# SITE DEVELOPMENT PLAN

## LOT 2, GREATER EUROPE MISSION SUBDIVISION FILING NO. 1

SITE DEVELOPMENT PLAN  
**MONUMENT STEEL STRUCTURES**  
 COVER SHEET  
 18910 BASE CAMP ROAD  
 MONUMENT, COLORADO

# Site Development Plan\_v1-redline.pdf Markup Summary

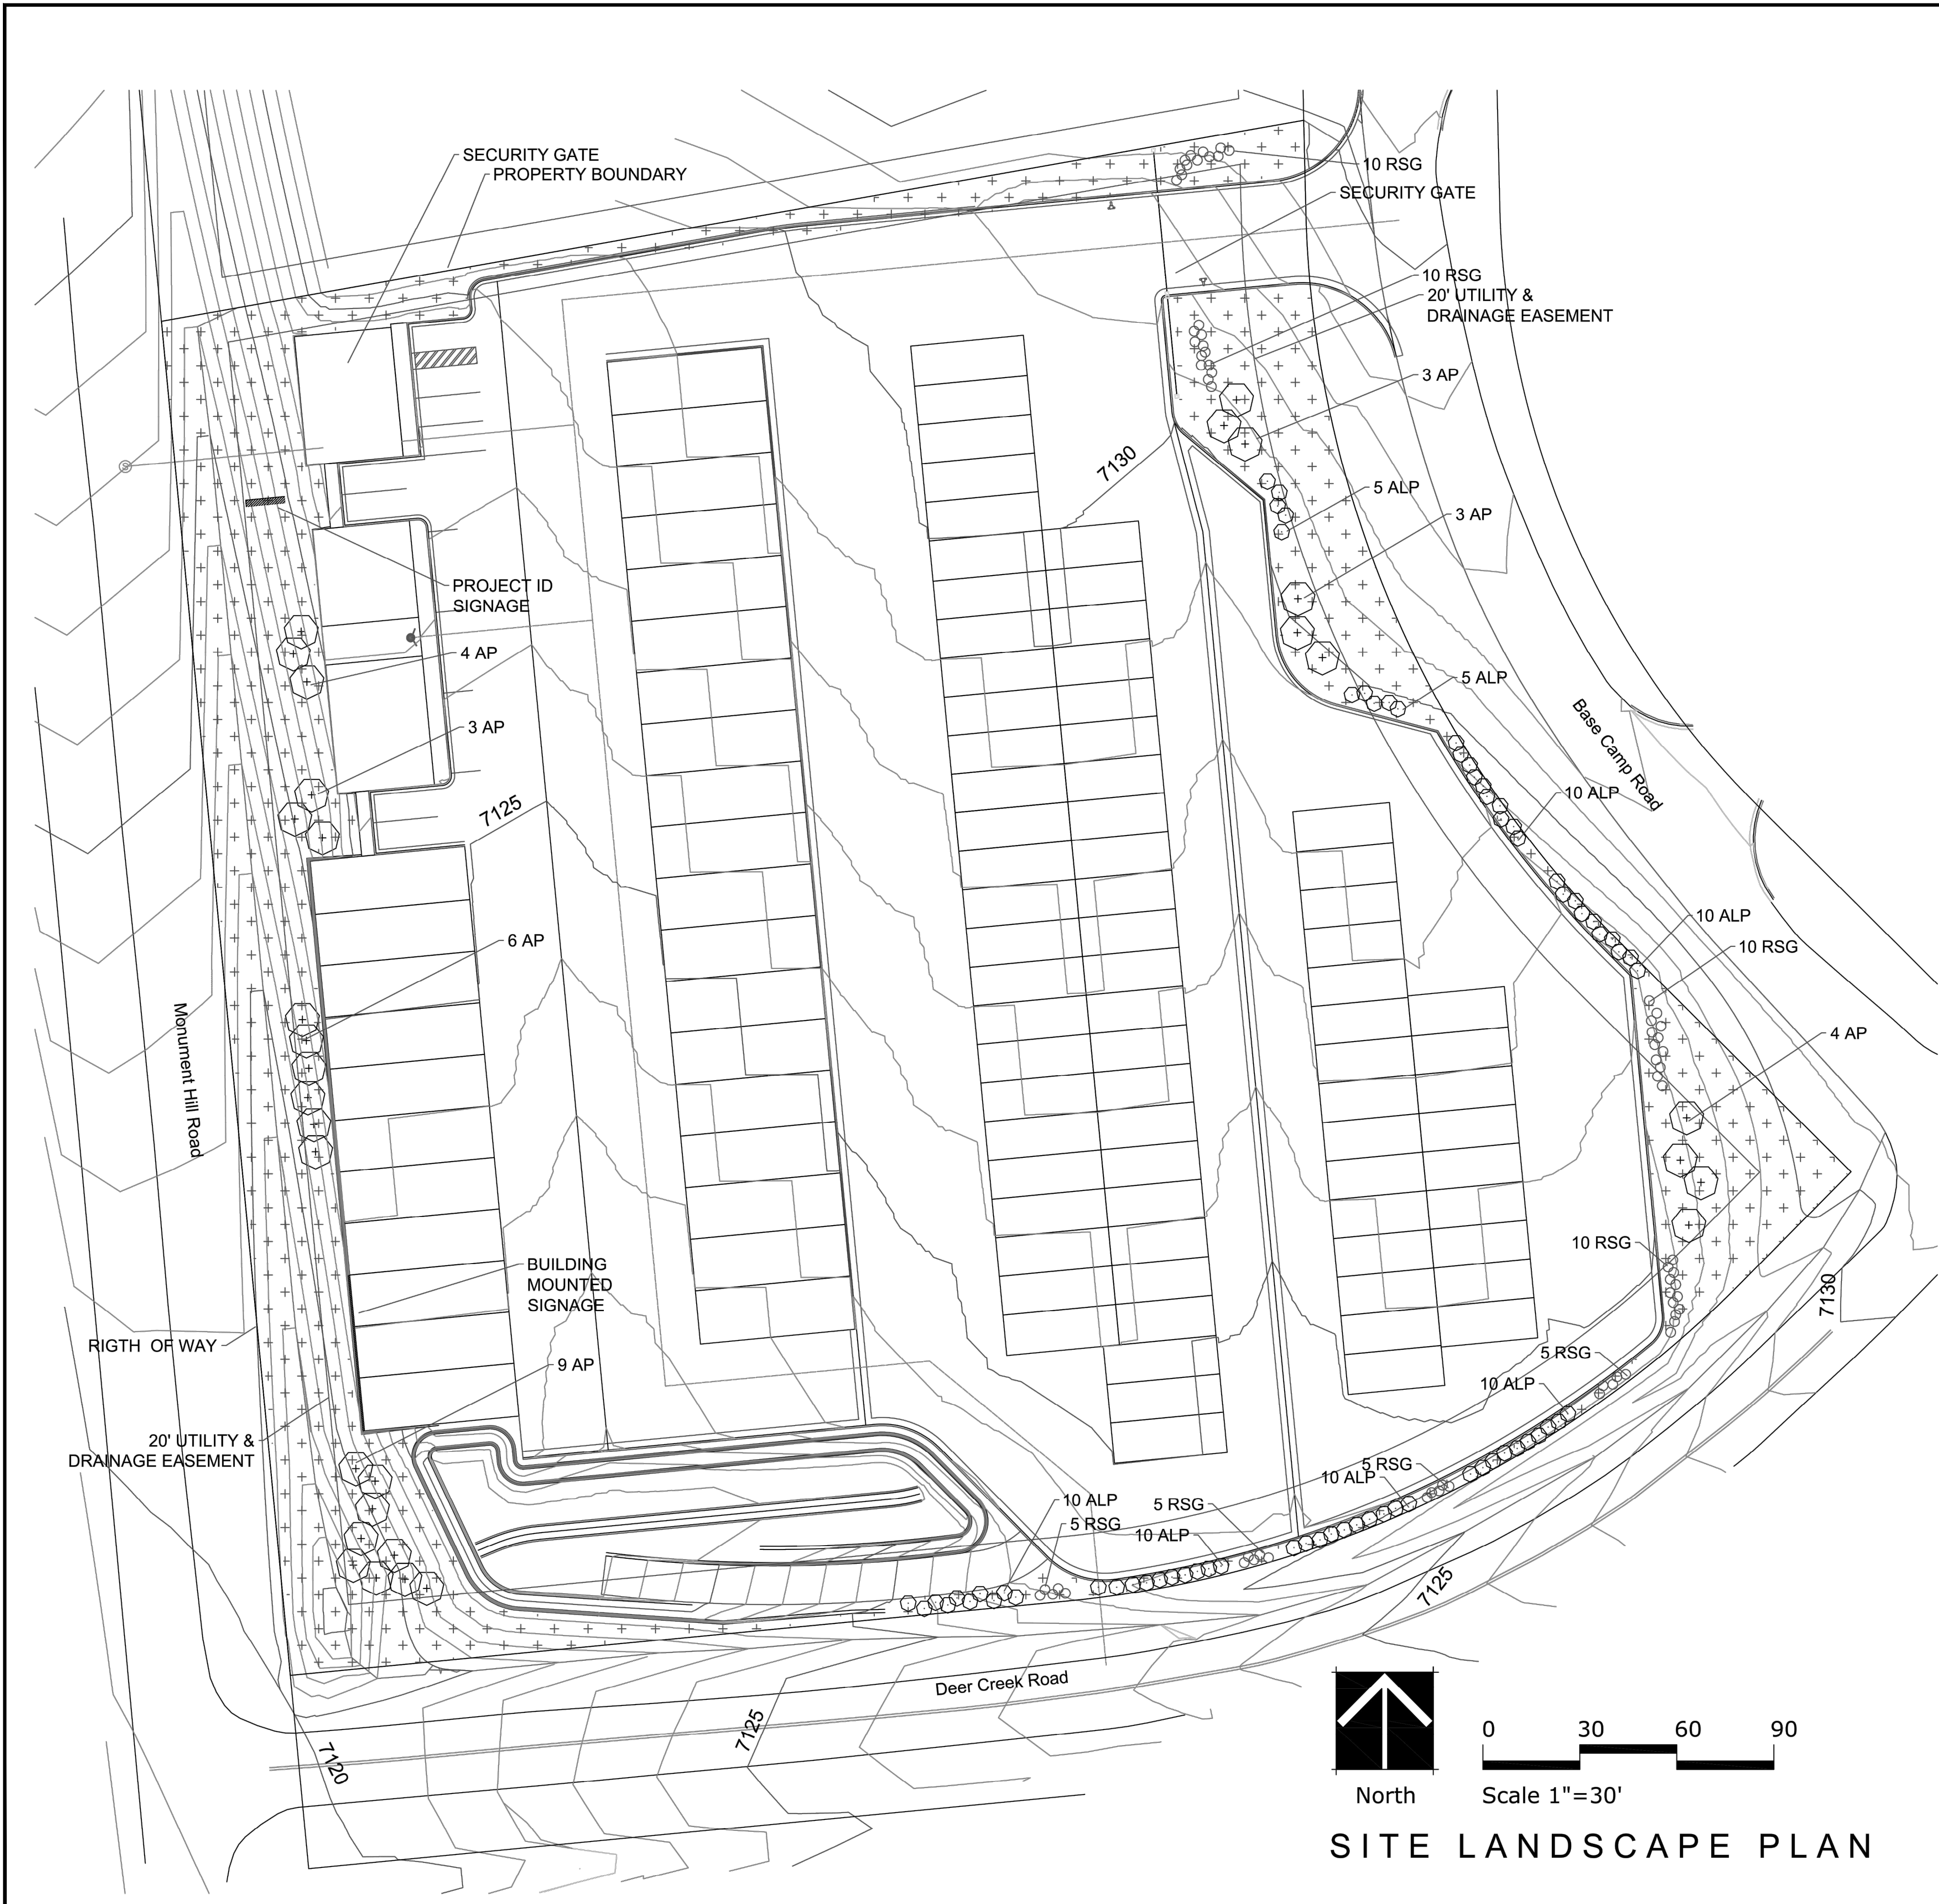
Show the intersection sight distance triangle. Reline is approximate only, see Engineering Criteria Manual Section 2.3.6.G for determining sight distance triangles. Any object within the sight distance triangle more than 30 inches above the adjacent road shall constitute a sight obstruction, and shall be removed or lowered.
